Dogger Bank South Offshore Wind Farms

**Appendix 29-1 Tourism and Recreation Consultation
Responses**

Application Reference: 7.29.29.1

Table 29-1-1 Consultation Responses Related to **Volume 7, Chapter 29 Tourism and Recreation (application ref: 7.29)**

Figure: 29-1 | Drawing No: PC2340-RHD-ON-ZZ-DR-Z-0690

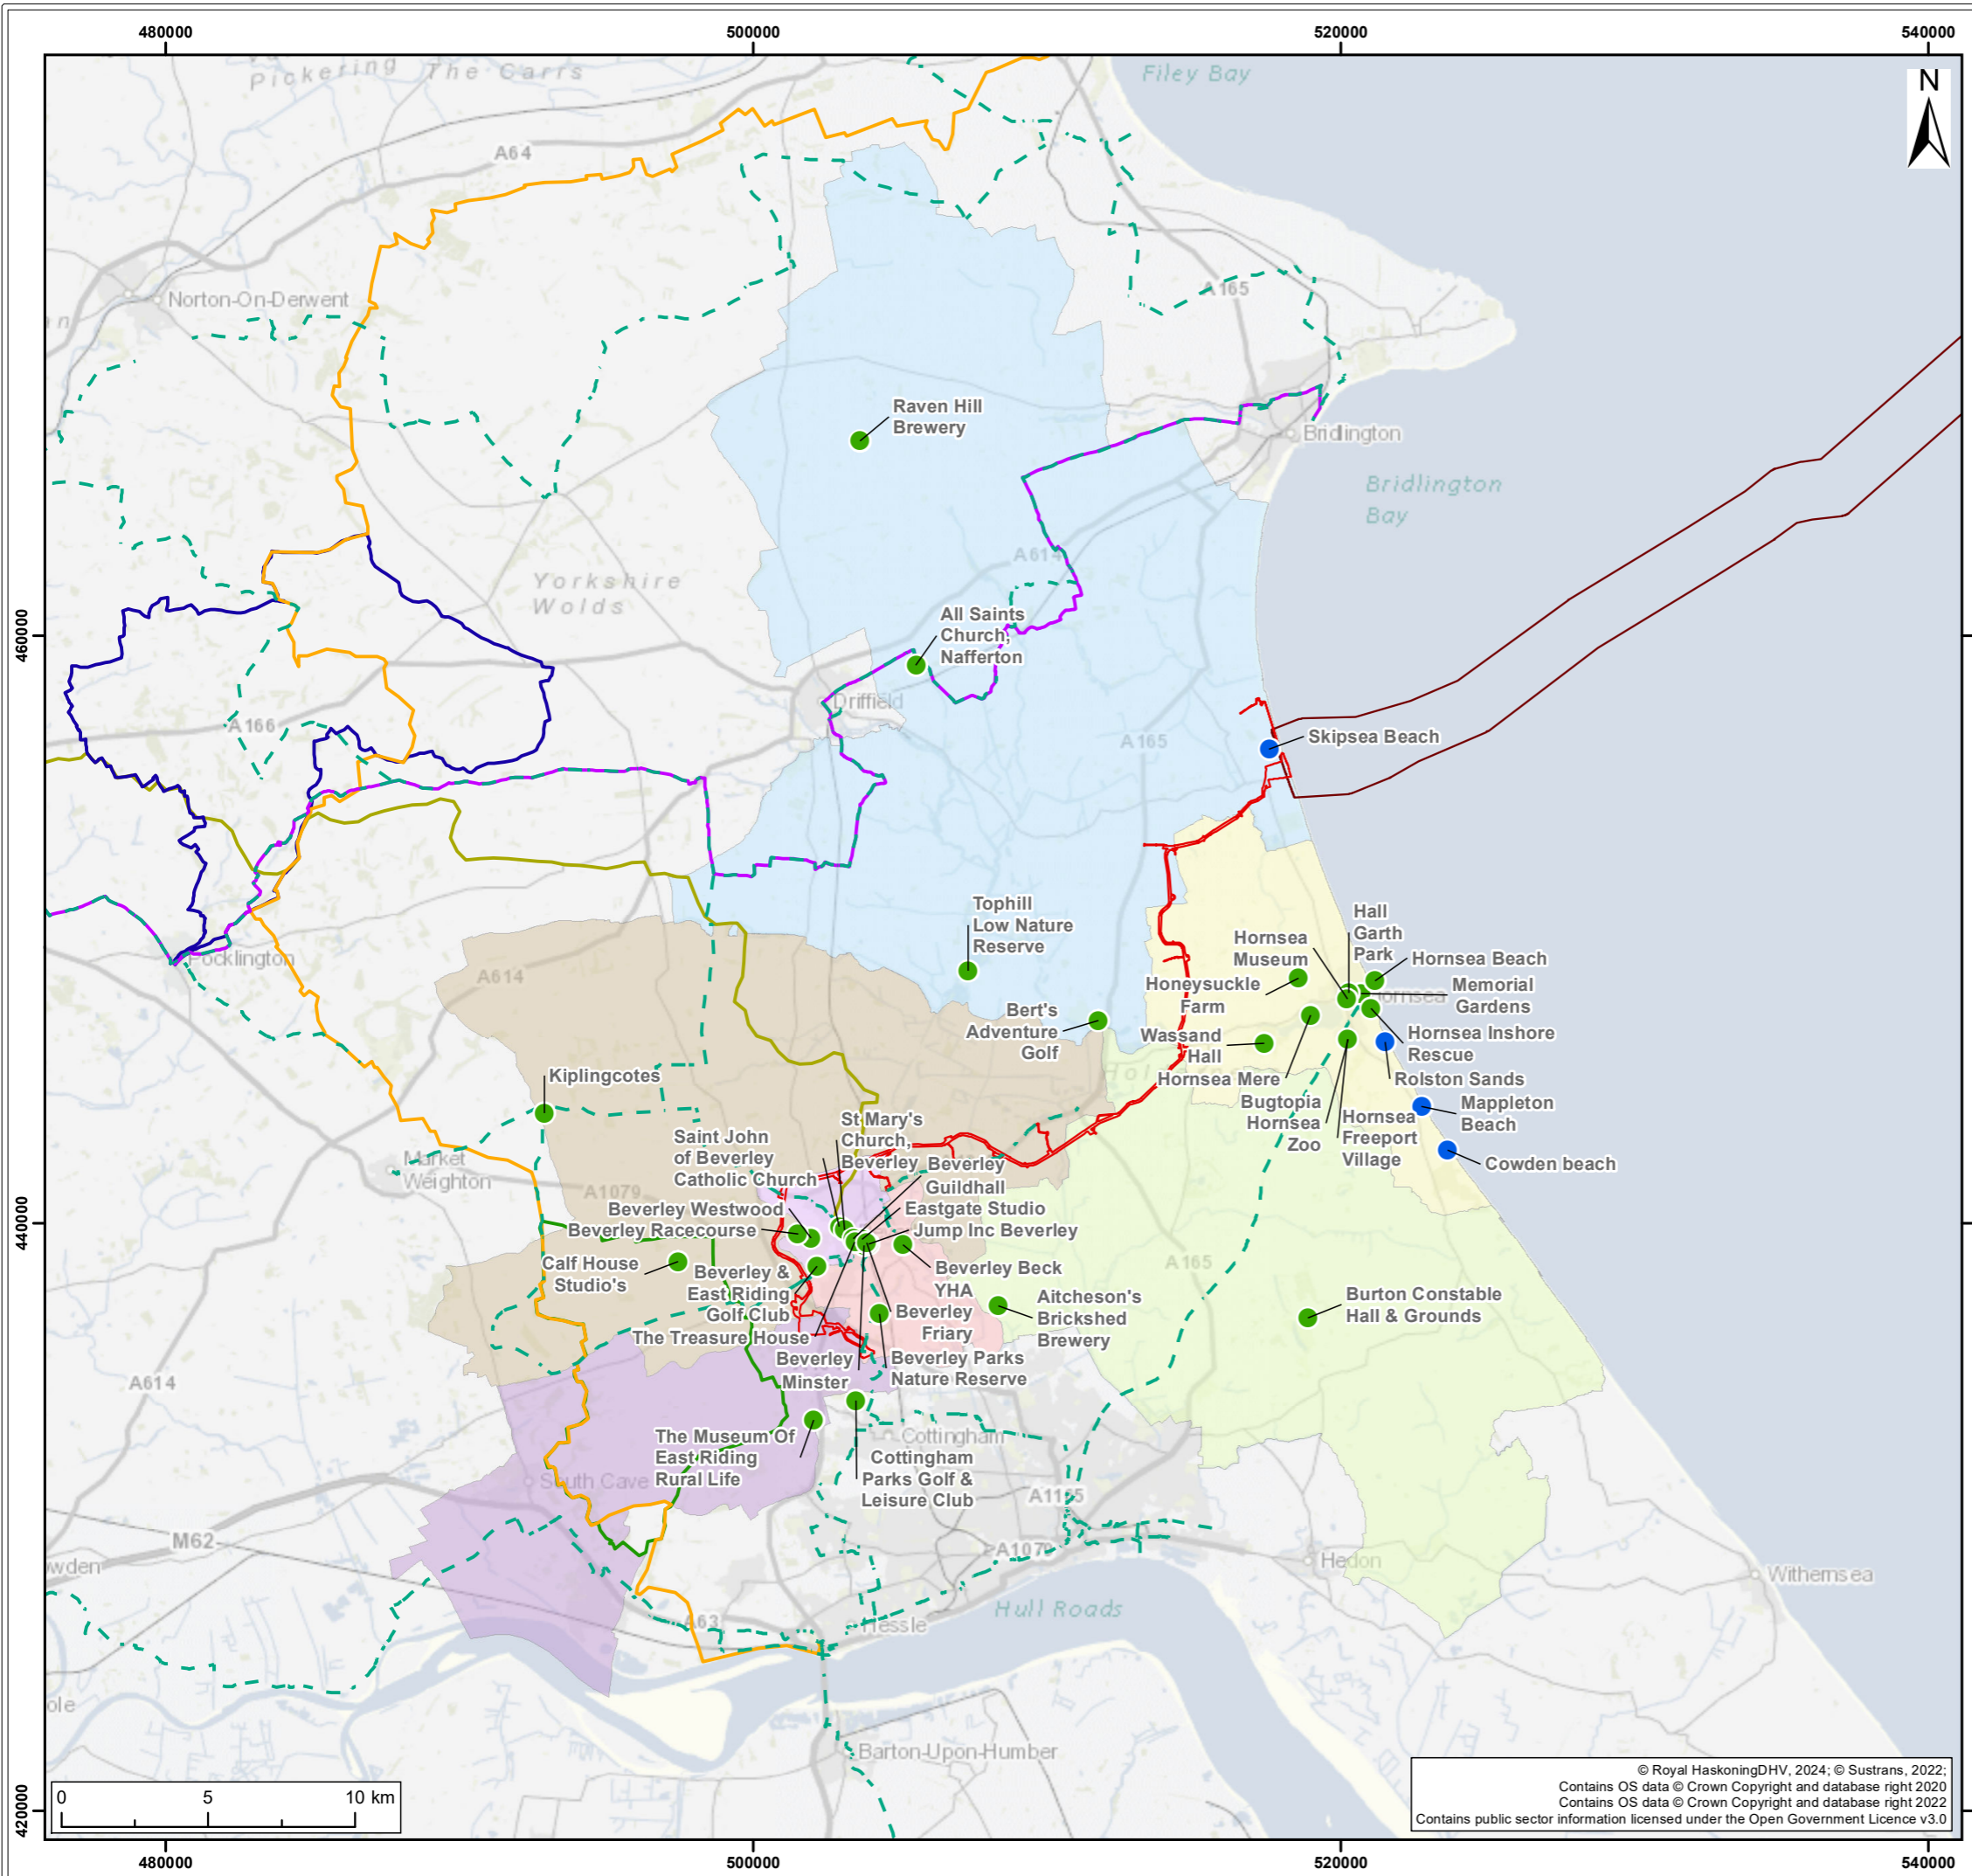
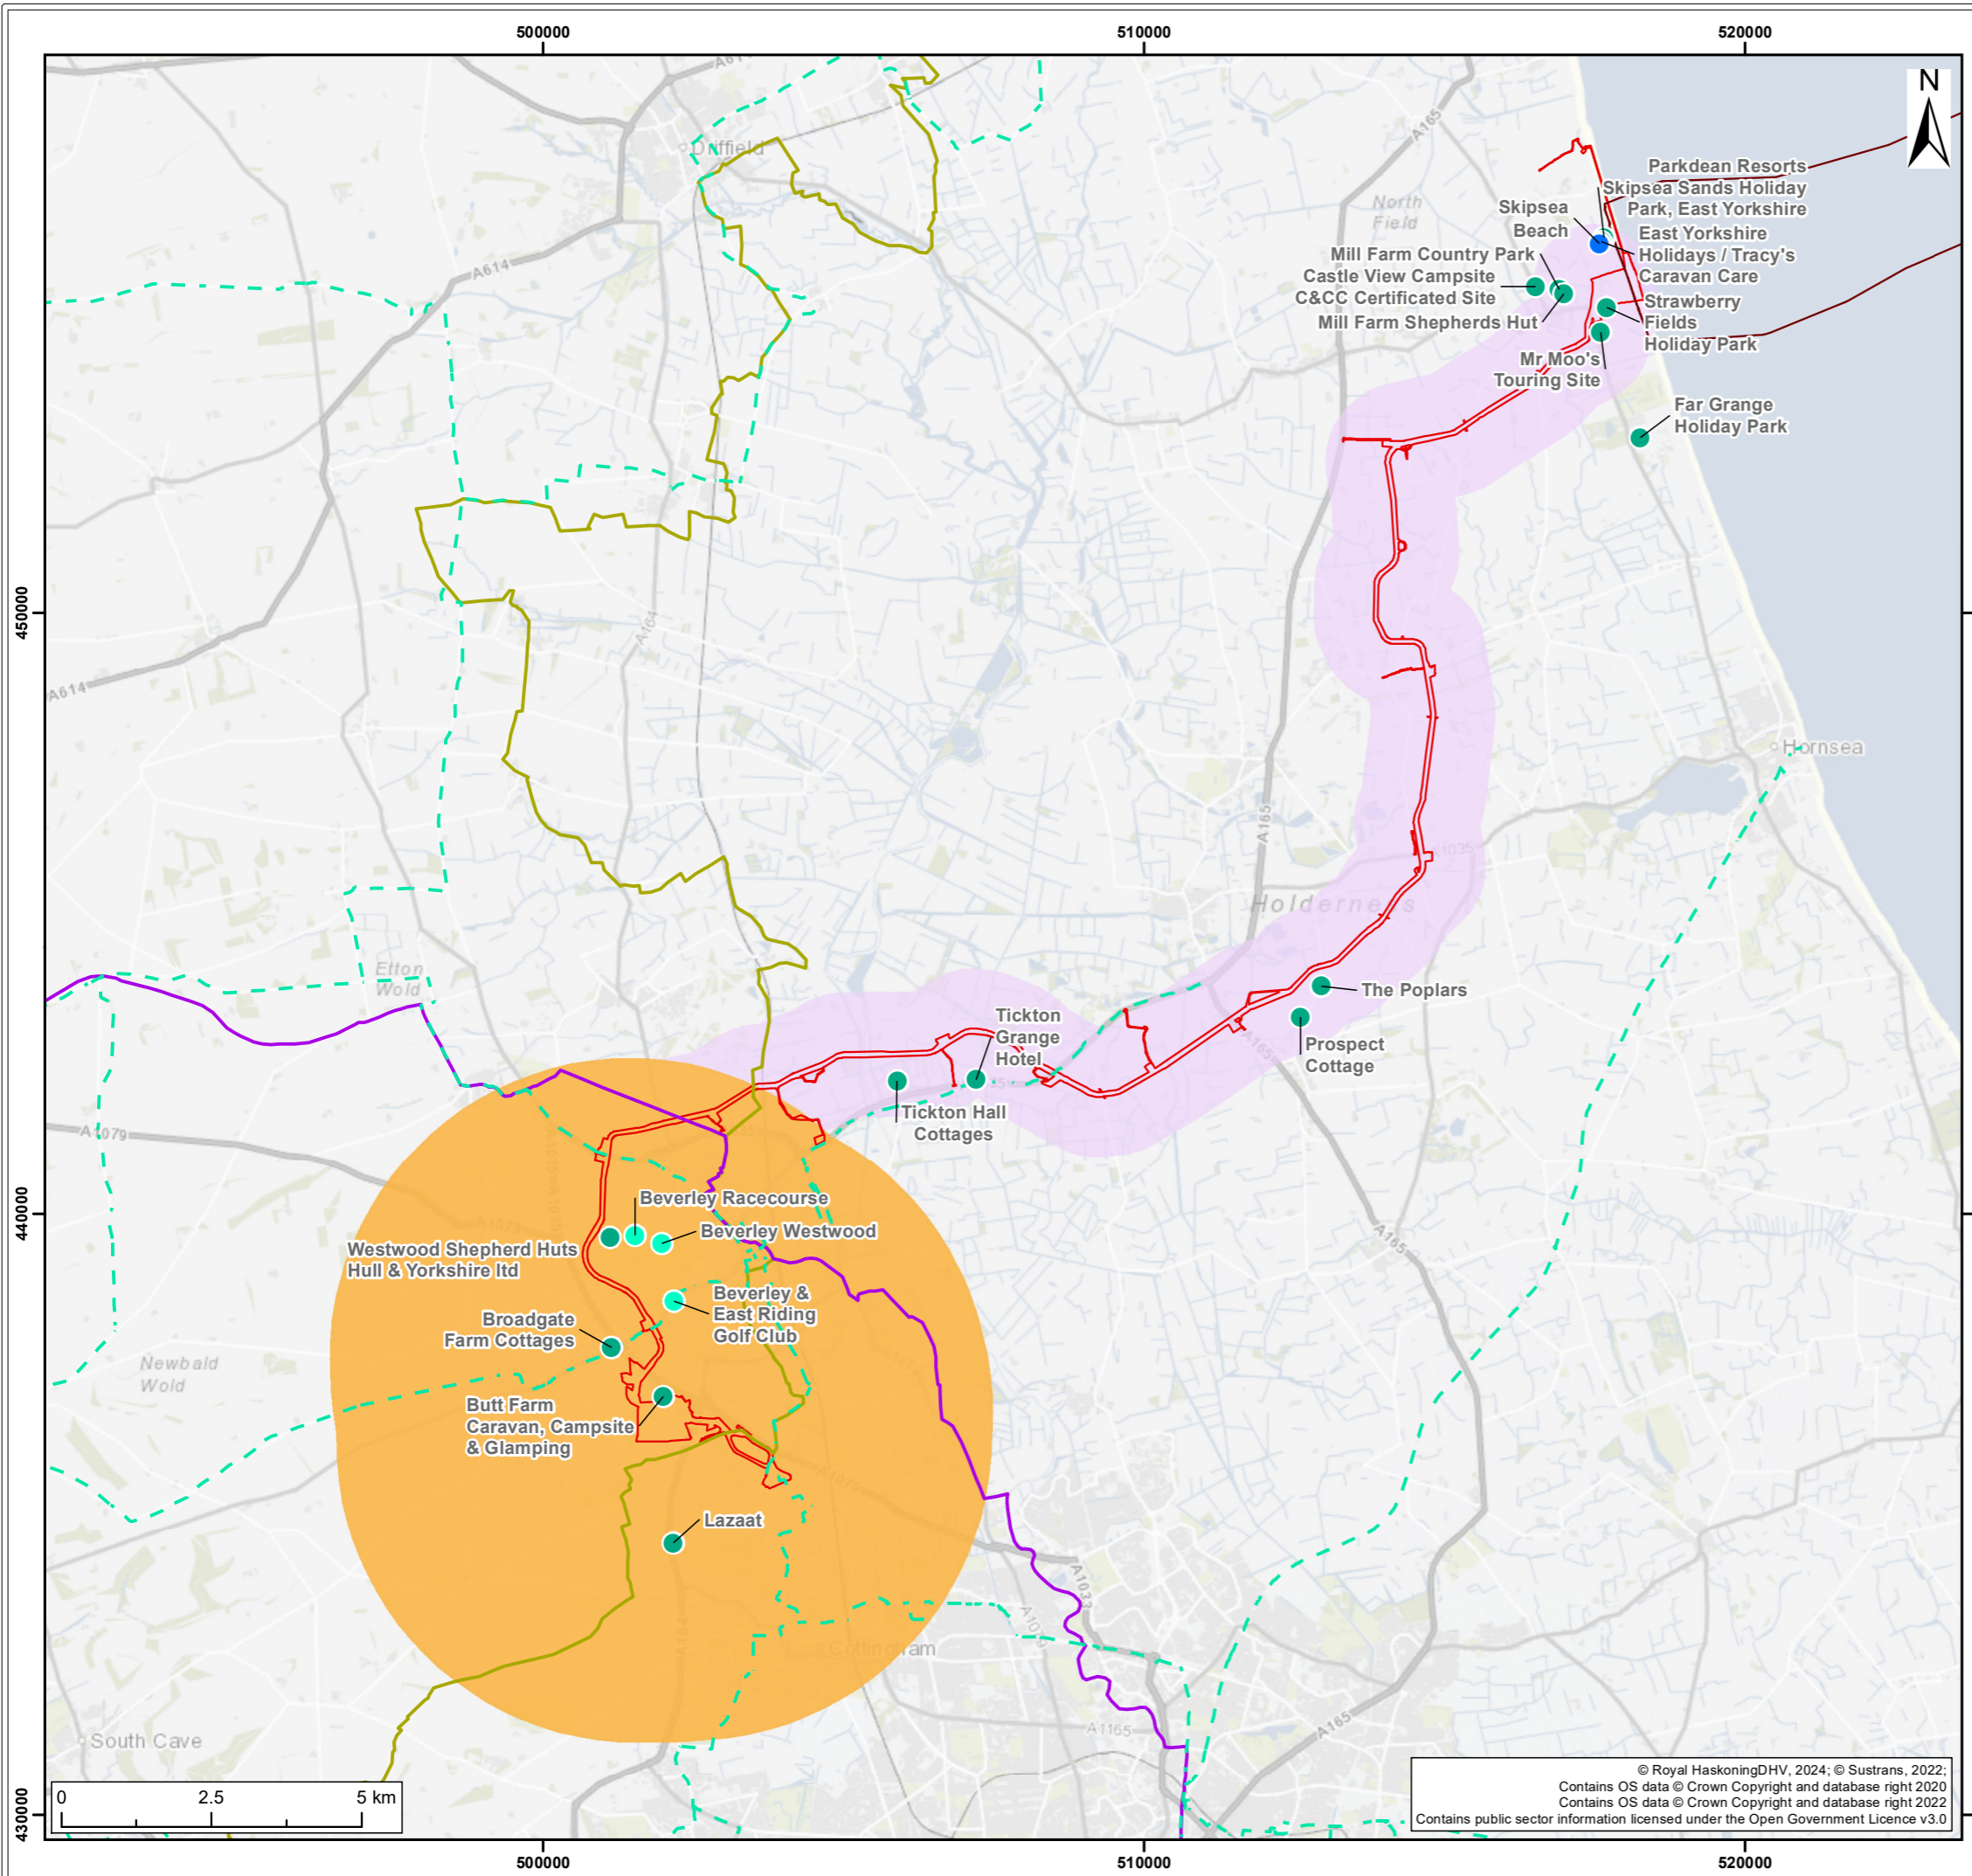
Section 42 Consultation - East Riding of Yorkshire and Kingston upon Hull Joint Local Access Forum July 2023	
<p>Joint Local Access Forum suggests the ECP (The King Charles III England Coast Path) should be recognised as an additional nationally important receptor when taking</p>	<p>The ECP (The King Charles III England Coast Path) is included in the Volume 7, Chapter 29 Tourism and Recreation (application ref: 7.29) baseline (section 29.5.6) and</p>
